Ku-ring-gai Council Submission

**Major Project MP08_0244 – Preferred Project Report –
Mixed Use Development - 23-37 Lindfield Avenue and 11 Havilah
Avenue, Lindfield**

August 2011

This submission provides comment from Ku-ring-gai Council to the Department of Planning on the *Preferred Project Report* (PPR) for major project MP08_0244 Construction of a Mixed Use Commercial, Retail and Residential Development at 23-37 Lindfield Avenue and 11 Havilah Avenue, Lindfield.

1 CONCEPT CORNER SITE DEVELOPMENT- BASEMENT  
1:200

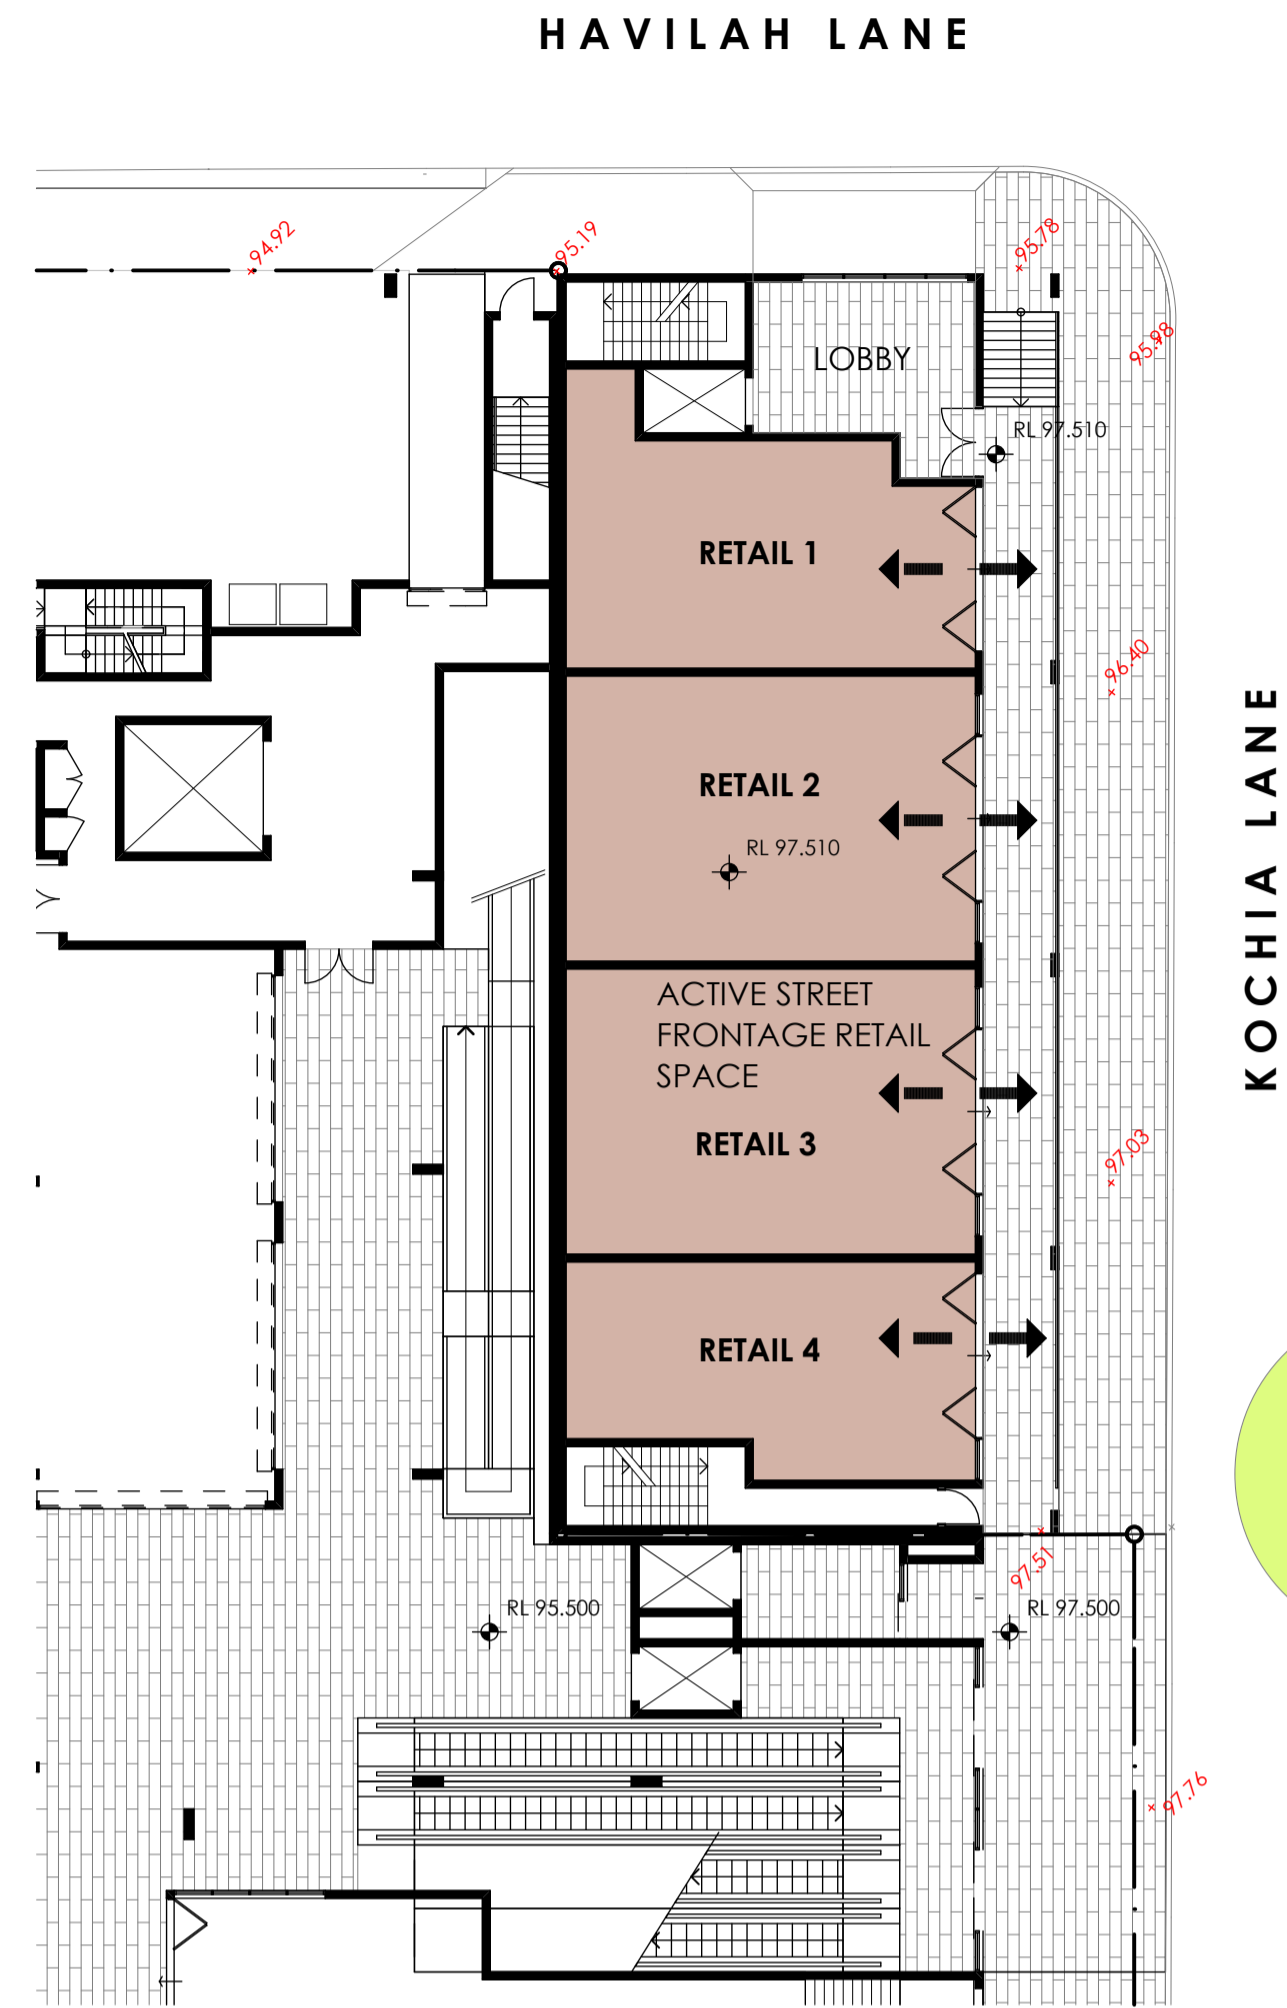
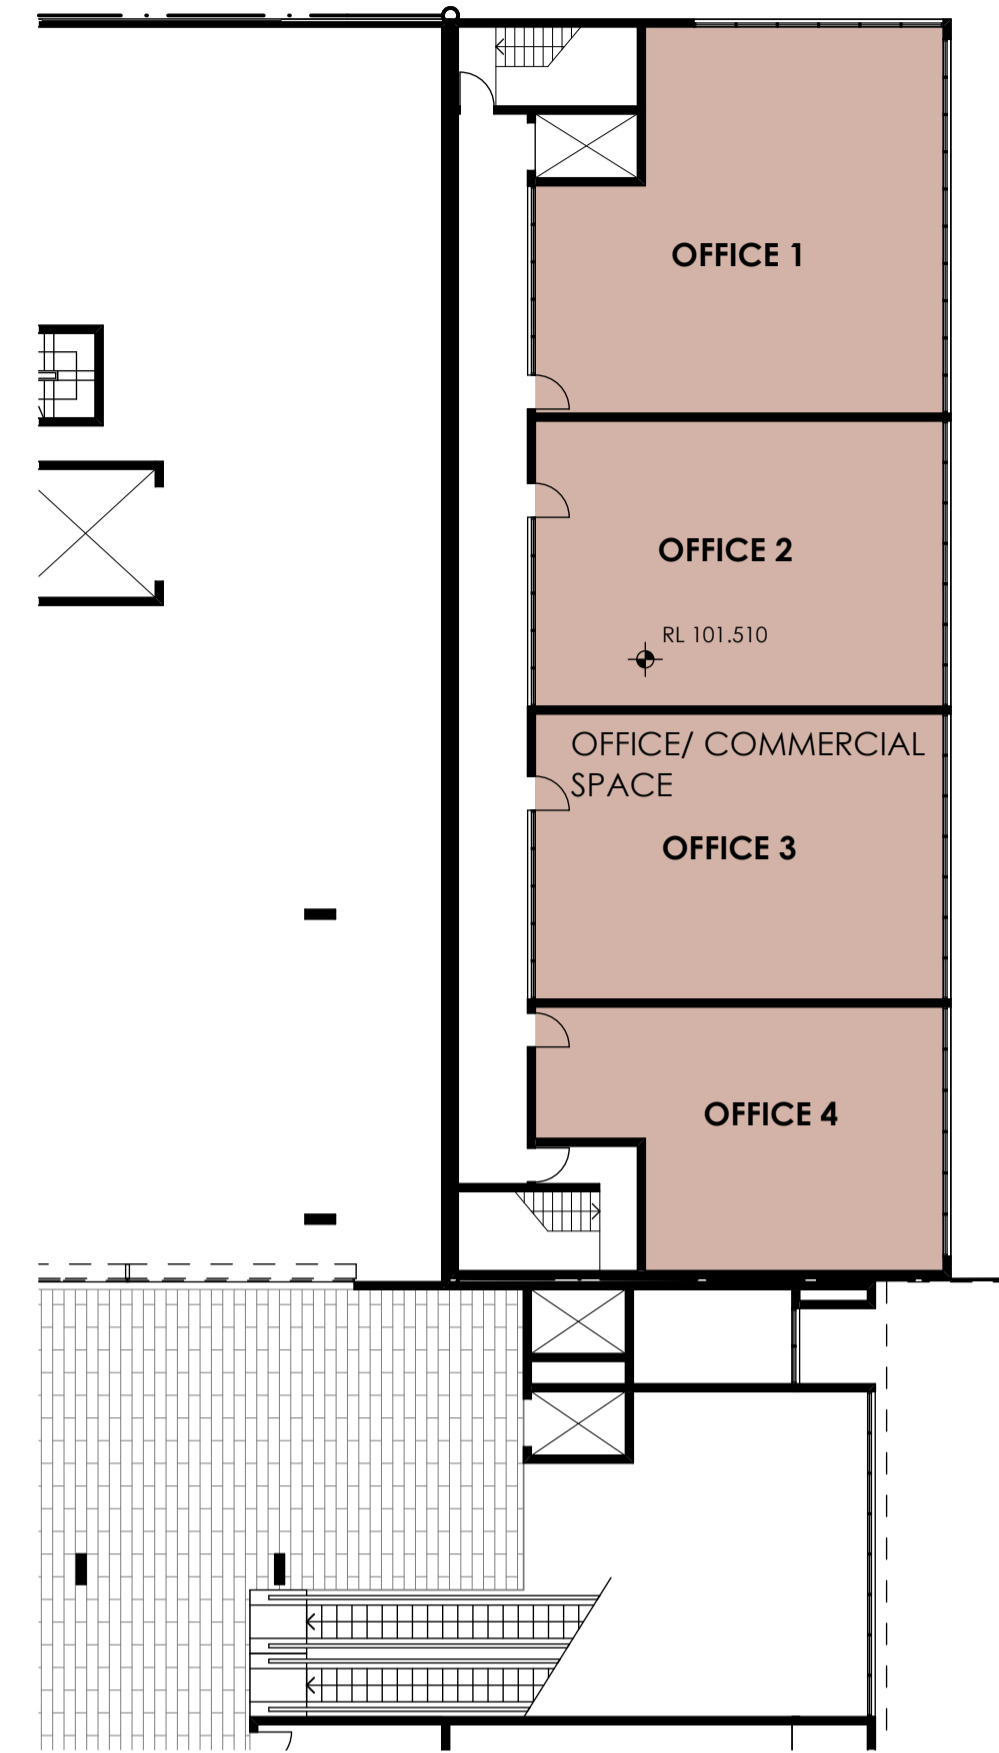
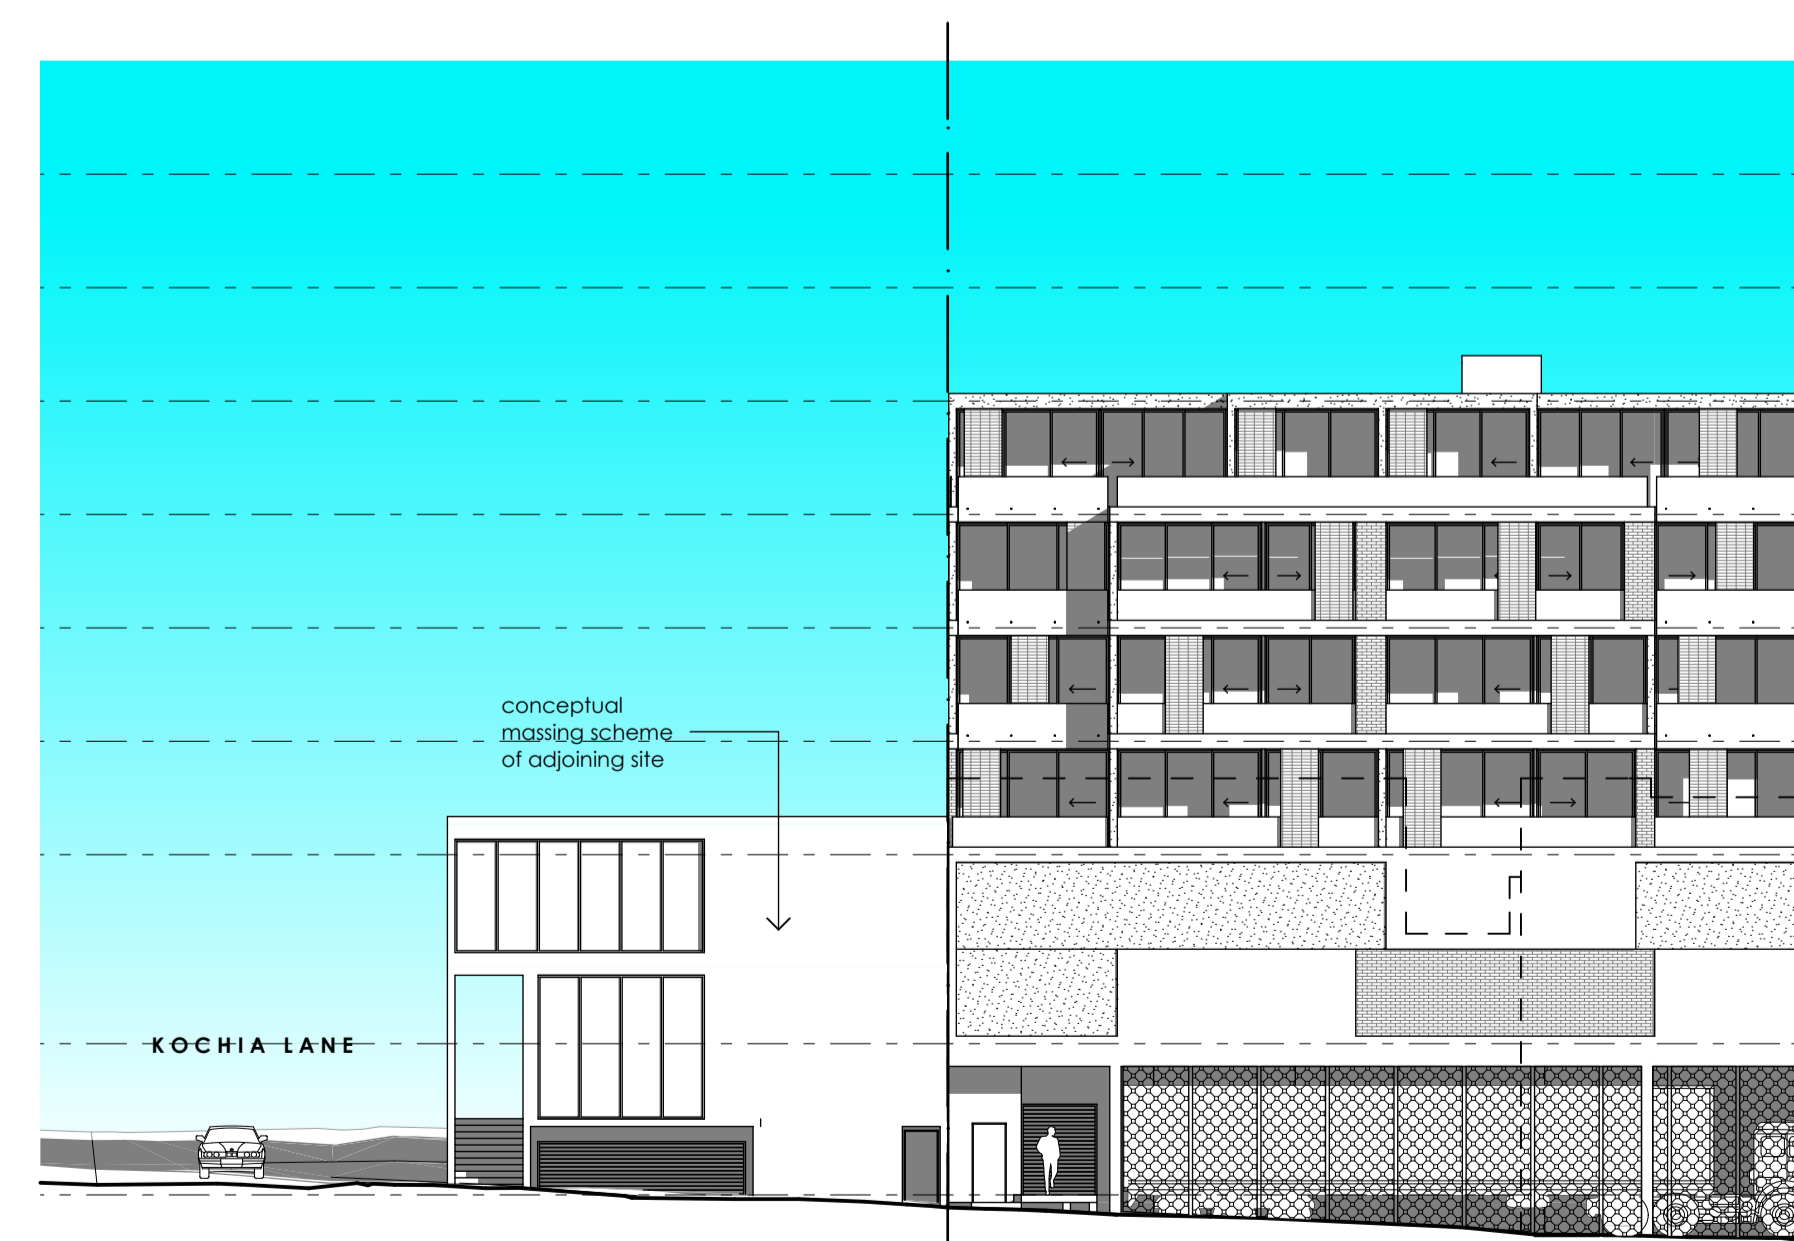
The PPR also attempts to demonstrate that the independent development of 2 Kochia Lane can be achieved. This is done by conceptual plan and elevation diagrams. Council does not believe that the physical plans alone satisfy requirement of the Land and Environment Court's planning principles regard economically viable development. There has been no attempt to demonstrate that such a development proposal would be financially feasible.

There is considerable doubt whether such a development, as presented, would actually be economically viable. Of particular note is that the parking requirements for the concept as presented would be approximately 23 spaces plus loading areas (the presented scheme only shows 9 spaces). This would require 2 to 3 basement levels for parking rendering the proposal cost prohibitive.
